DRB Application No.: 05DRB-01133 (P&F) Project # 1004281  
Project Name: RIVERVIEW SUBDIVISION  
Agent: Mark Goodwin & Associates Phone No.: 828-2200

Project Name: RIVERVIEW SUBDIVISION

**CITY OF ALBUQUERQUE  
PLANNING DEPARTMENT  
July 20, 2005  
DRB Comments**

SCHLEGEL LEWIS ARCHITECTS agent(s) for VENTURA PACIFIC CAPITAL COMPANY request(s) the above action(s) for all or a portion of Tract(s) H-6A7A1, **RIVERVIEW SUBDIVISION**, zoned SU-1 IP, located on GOLF COURSE RD NW, between PASEO DEL NORTE NW and SHELLY ROSE RD NW containing approximately 1 acre(s). [REF: DRB-97-245] (C-12)

Q Site Plan

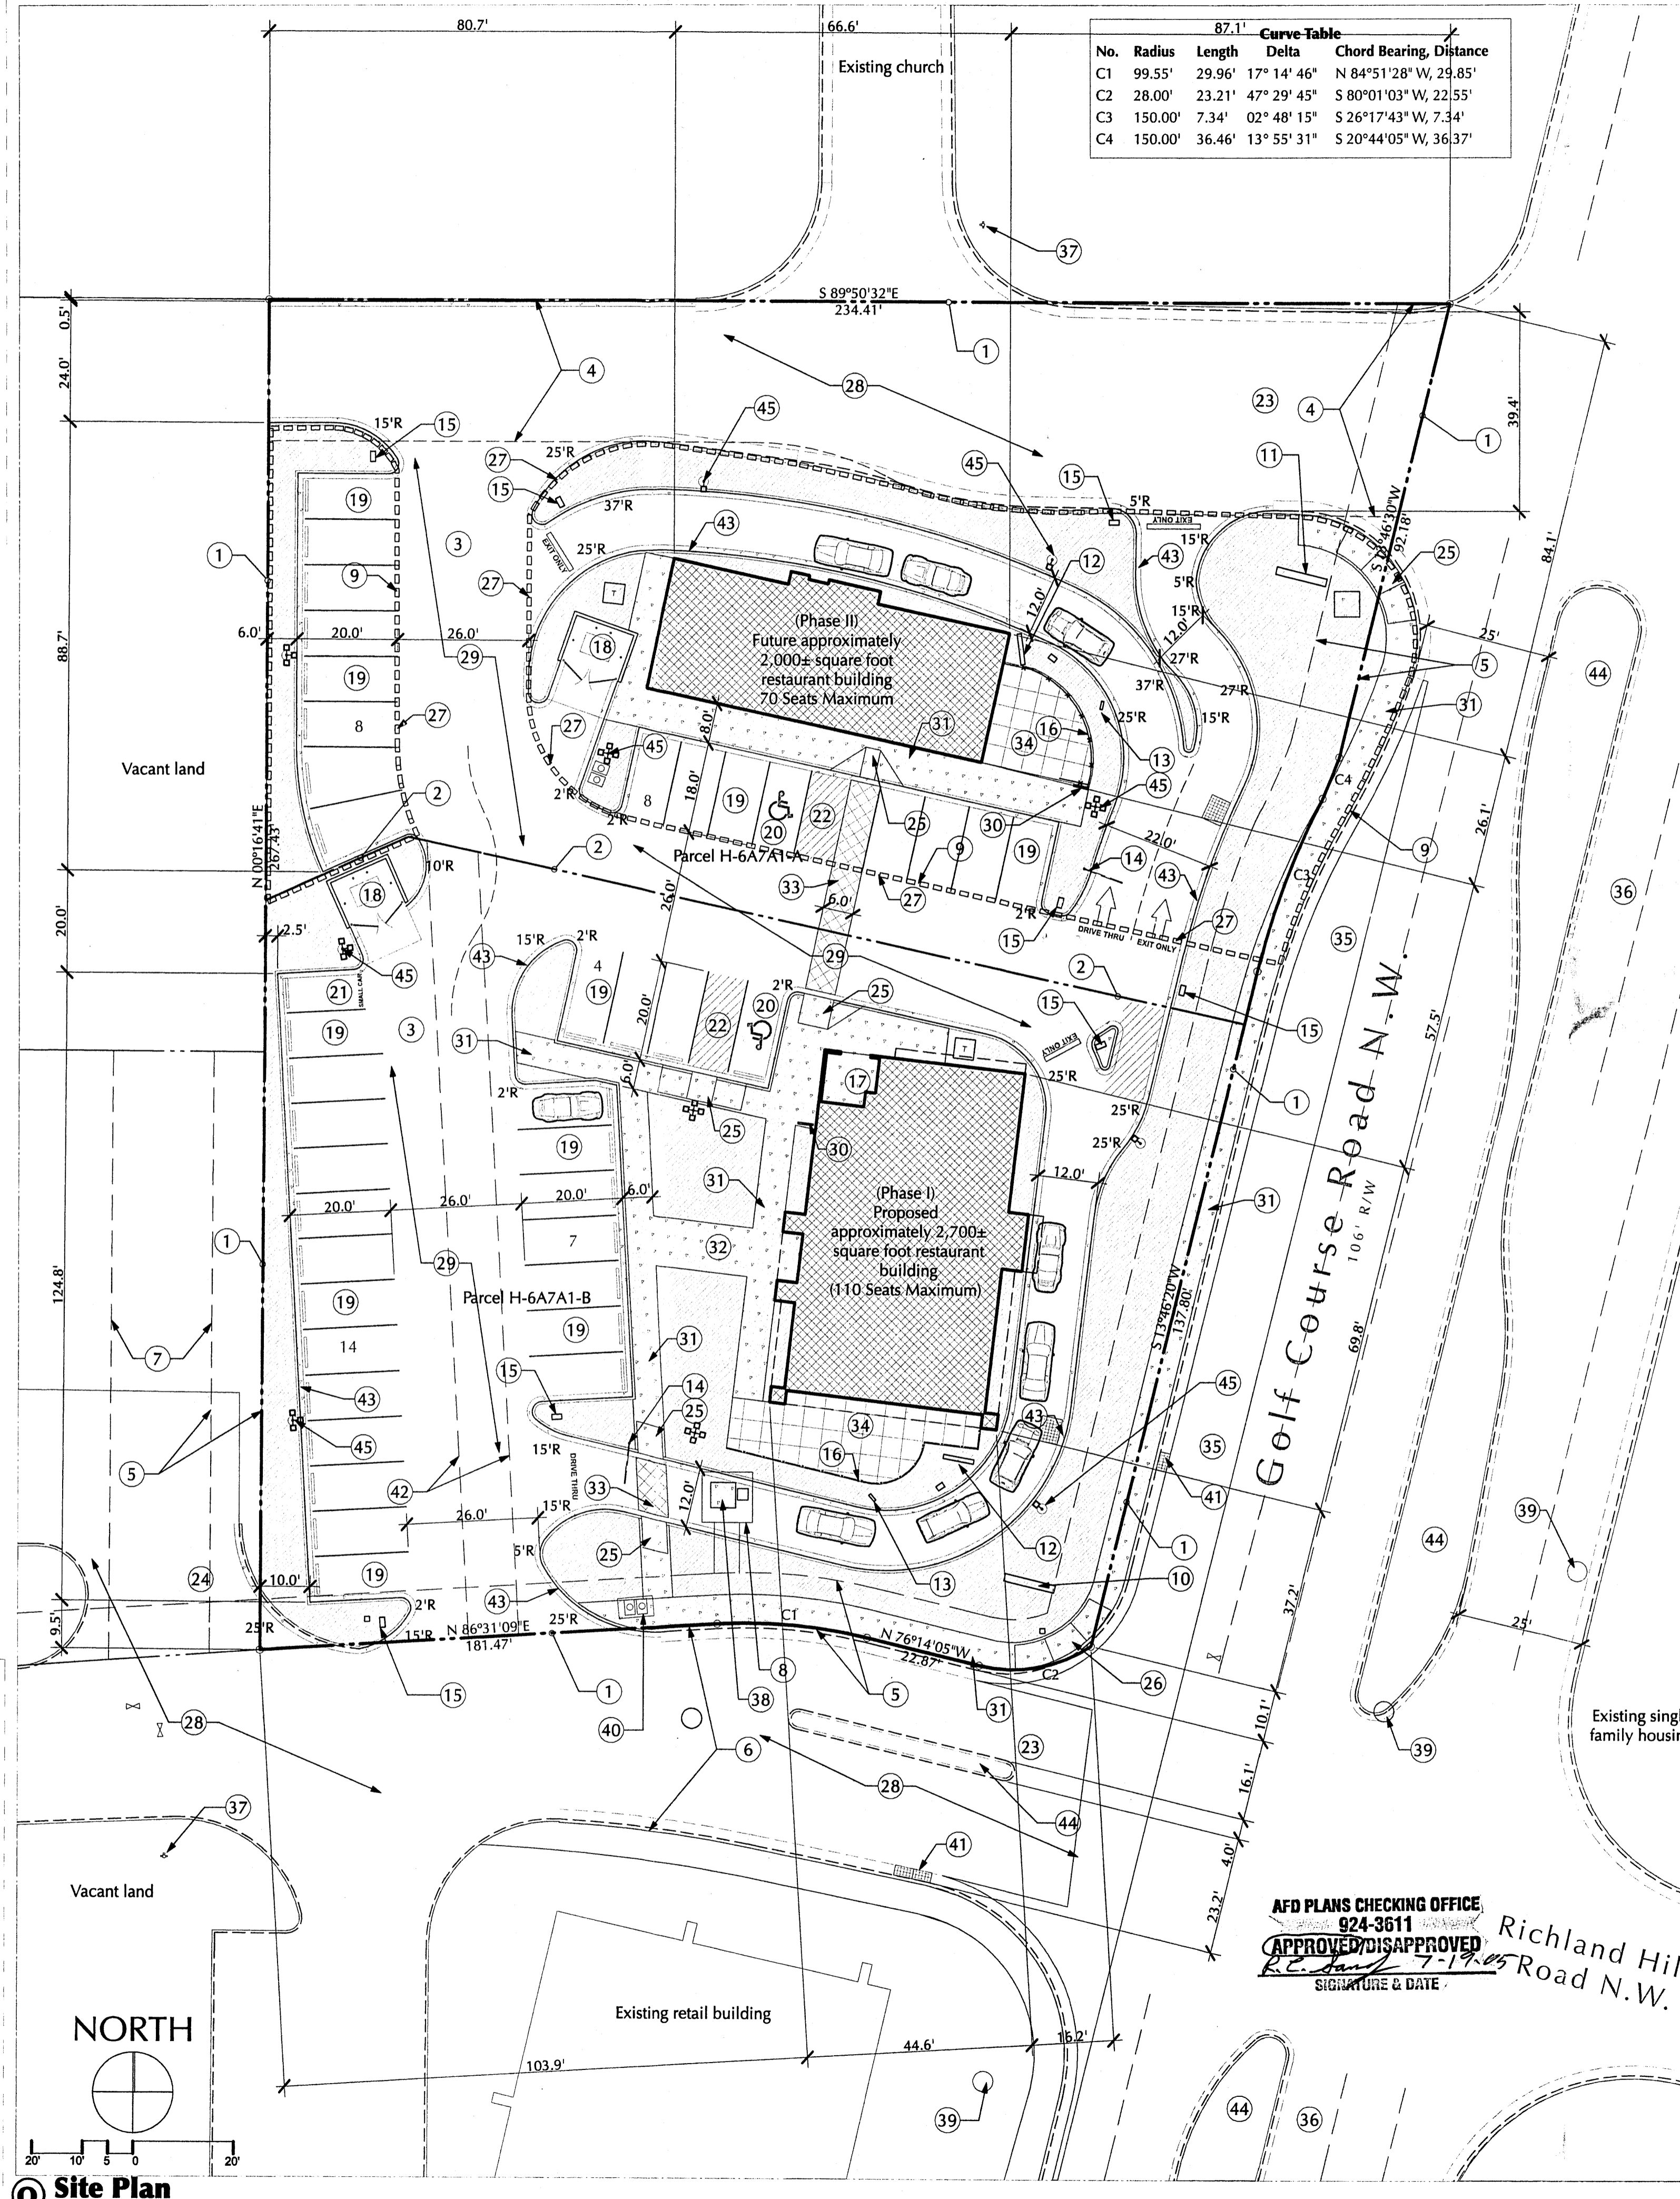
Transit suggests providing a pedestrian connection from the sidewalk along Golf Course to at least the northern restaurant building, potentially at approximately the location where the driveway width is marked at 22' just north of the drive-through clearance menu sign. This location would provide better access to the site for pedestrians arriving from the north.

Sidewalks adjacent to the primary entrance of the building must be eight feet wide for the entire length of the façade. Six-foot wide sidewalks are insufficient per the Code.

Please provide a floor plan. Parking requirements for this development are determined by the seating in the restaurant. This is not shown correctly on the plan.

- The parking calculations should be on this sheet.
- The pedestrian walkway between buildings should be separate from the handicap van aisle. The van aisle is to allow the operation of a chair lift.
- Light fixtures are limited to 20' maximum height per the Zone Code and the Northwest Mesa Escarpment Plan.

**Landscape Plan**

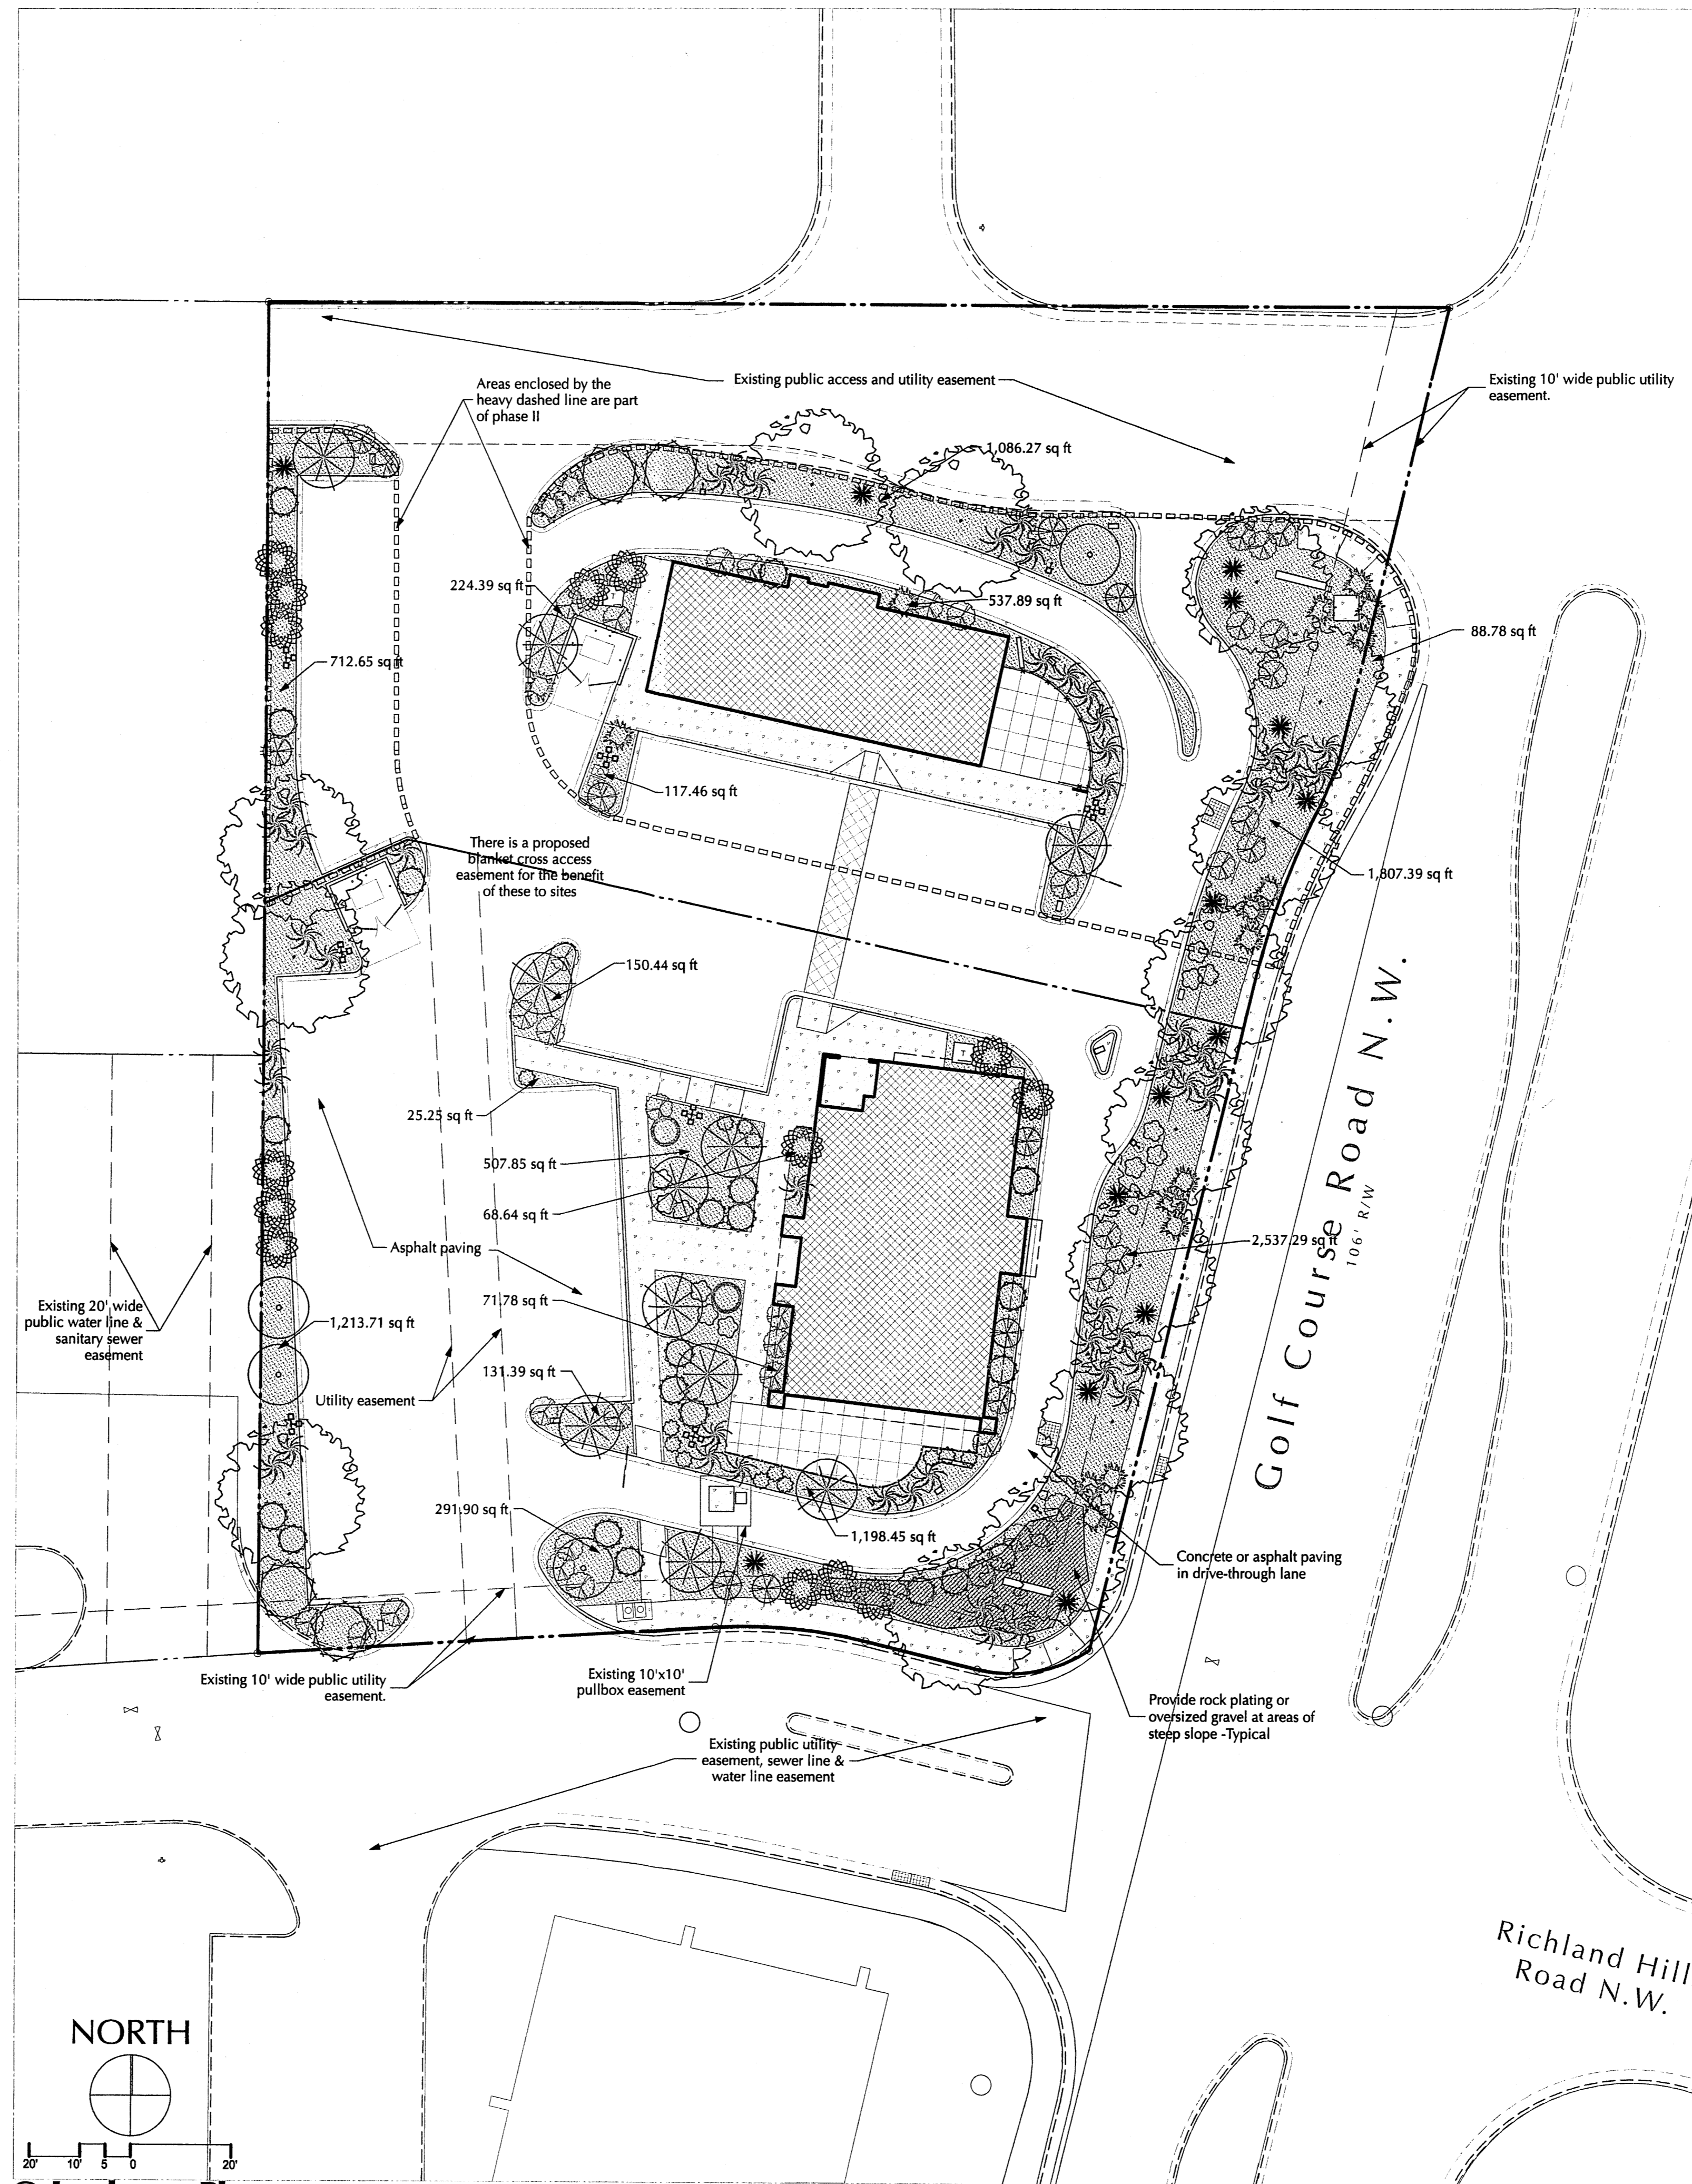
Desert willow and New Mexico Olive are trees. All trees planted as part of the required landscaping must be two inches caliper six inches above the grade after planting, or ten to twelve feet tall after planting. These two tree types as indicated on the landscaping plan do not meet this requirement. (Gallon size is not an accurate method to determining compliance with the ordinance.)

- The Northwest Mesa Escarpment Plan has a list of approved plants. Most of the plants on the Plan are okay. The Flowering Pear is not on the list & is a high water user. Please substitute another ornamental tree which does not exceed 30' in height and is not a high water user.
- The 15% landscaping requirement is planted areas, gravel with no plants is not counted.
